The Drax Power (Generating Stations) Order

Environmental Statement Appendix 1.2 - Scoping Opinion

SCOPING OPINION

Proposed Drax Repower Project

DRAWING No: 70037047-3.2	REV: A
-----------------------------	-----------

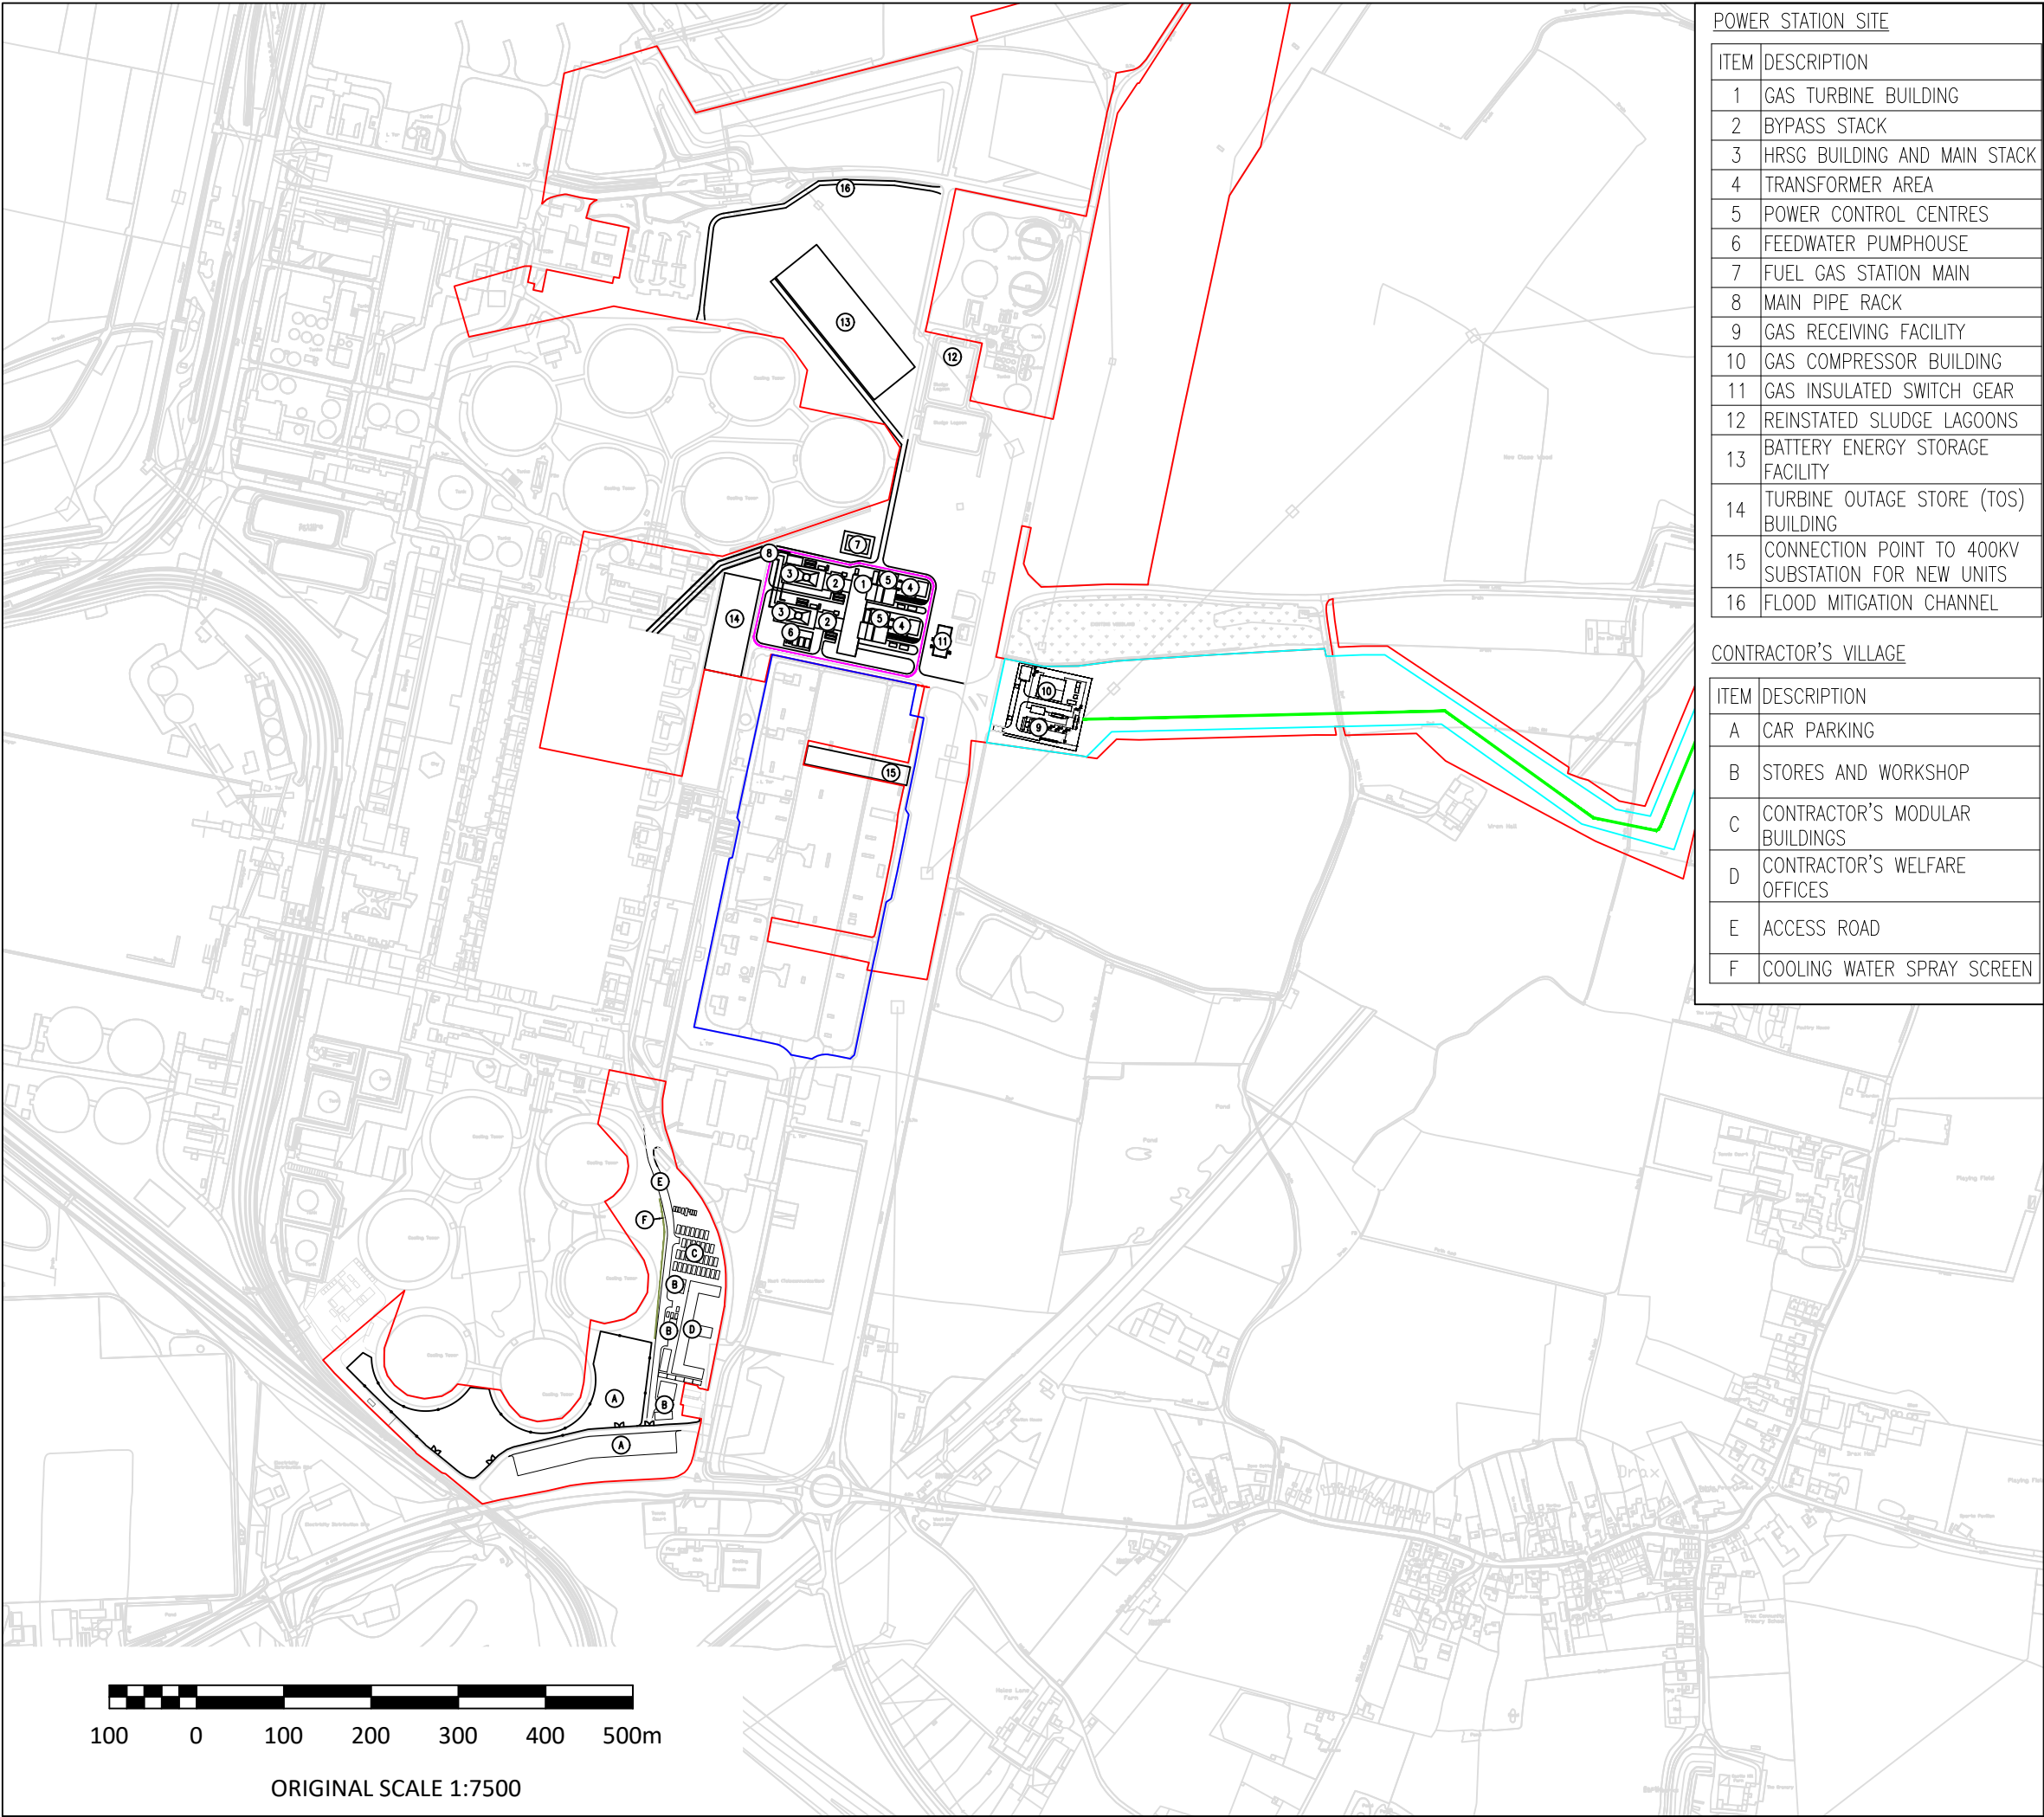
- 2.3.3 The Scoping Report states that there would be up to four Heat Recovery Steam Generators, each with a main stack up to 70m in height. A bypass stacks would also be required. The ES should identify not only the height and number of stacks, but also their diameters and locations.

70037047-3.4

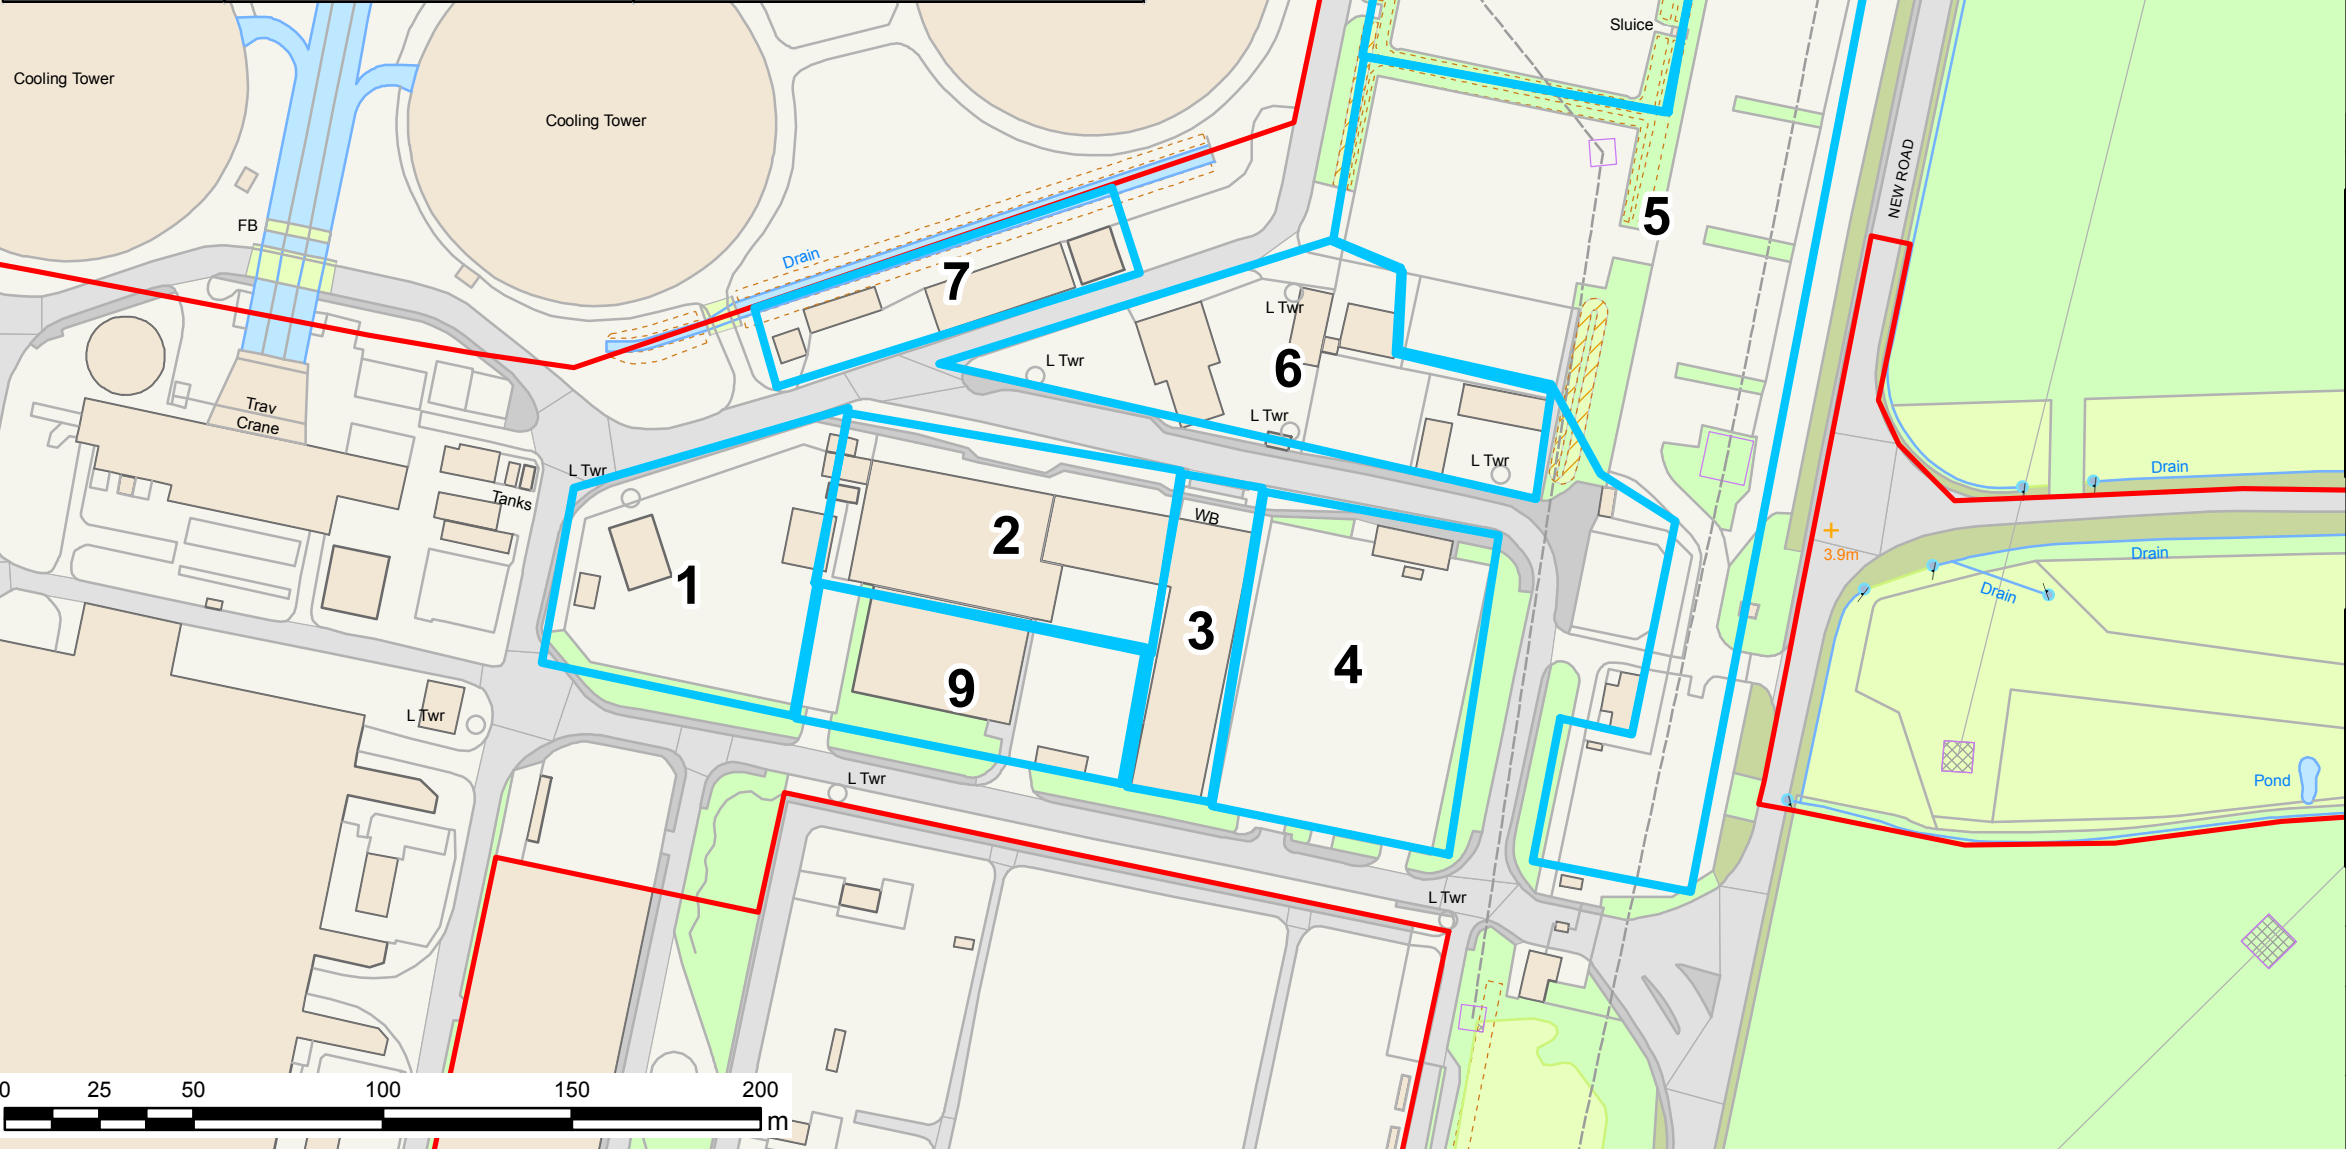
- 2.3.6 The ES should provide full details of the requisite demolition works; it should also be clear within the ES exactly which of the existing

facilities would be demolished and which would remain. The Inspectorate considers that figures would be useful to visually depict this.
